Our Ref: F2012/00304

15 January 2013

**STATE SIGNIFICANT DEVELOPMENT APPLICATION: UNSW MATERIALS
SCIENCE AND ENGINEERING BUILDING REF: (SSD 5373)**

The image below shows existing parking spaces, spaces that will be lost as a result of the proposed works. The existing spaces are based on UNSW Facilities Management, Location of Parking Spaces plan.

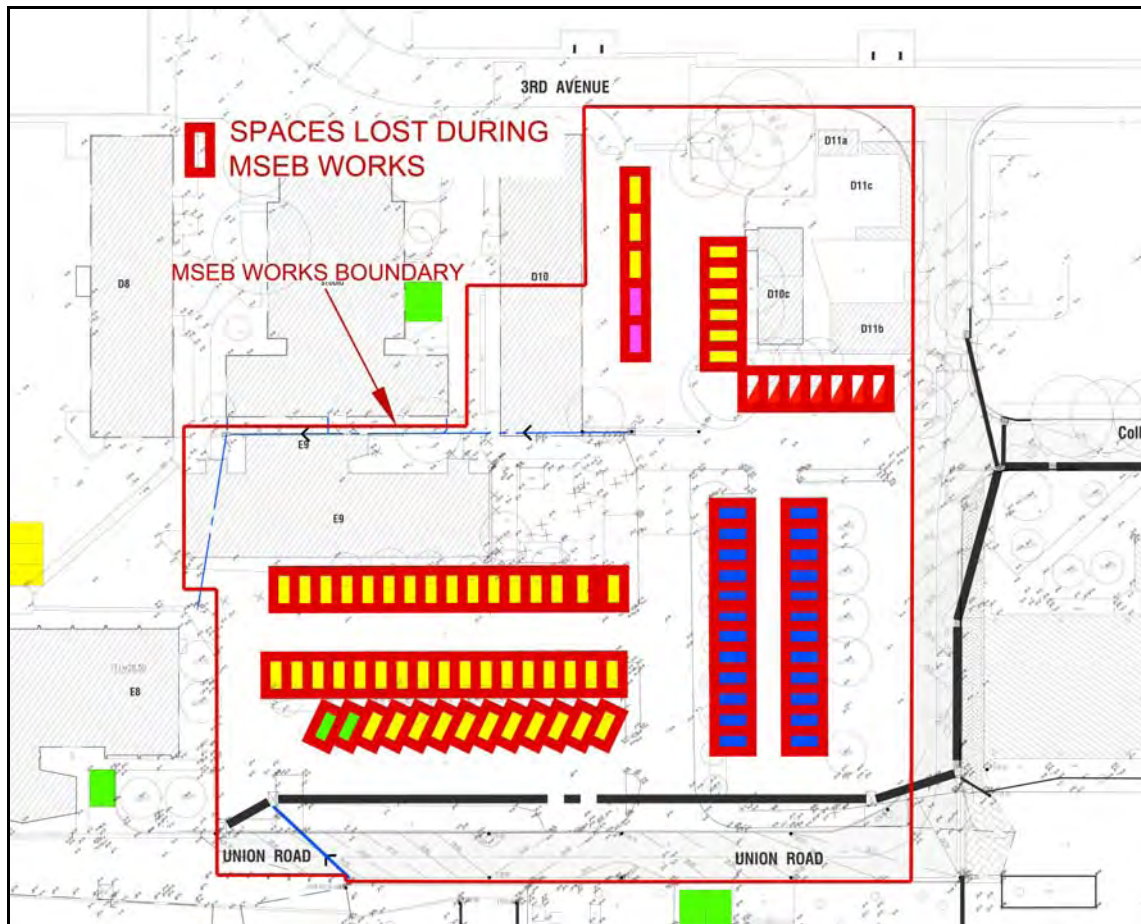
Loss of 84 spaces (including 2 disabled and 1 carshare space)

The proposed development will require the removal of 84 car spaces on lower campus including 2 disabled spaces and a carshare space operated by GoGet Carshare. The traffic and parking study attempts to justify this by noting that the total amount of parking spaces on campus will actually increase by 1 space when taking into account recent redevelopments around the campus.

It is Development Engineering's view that this approach is fundamentally flawed as it fails to recognize the increased parking demand generated by the redevelopment within the campus and the significant reduction of parking availability to permit holders and visitors.

It also does not recognize the geographical nature of the parking demand with Lower Campus likely to experience a severe parking deficiency as a result of this proposal. The University of NSW is a large campus and offsetting parking demand by re-developments on the other side of campus is not always considered appropriate especially as any additional spaces created elsewhere will be used to fulfil the surplus demand generated by that redevelopment and will unlikely be available to users on the other side of campus.

The loss of the carshare space is not consistent with the sustainable transport objectives and at minimum this space shall be relocated elsewhere on lower campus, with additional share spaces considered. The loss of the carshare space is not acknowledged in the accompanying Traffic and Parking Report.
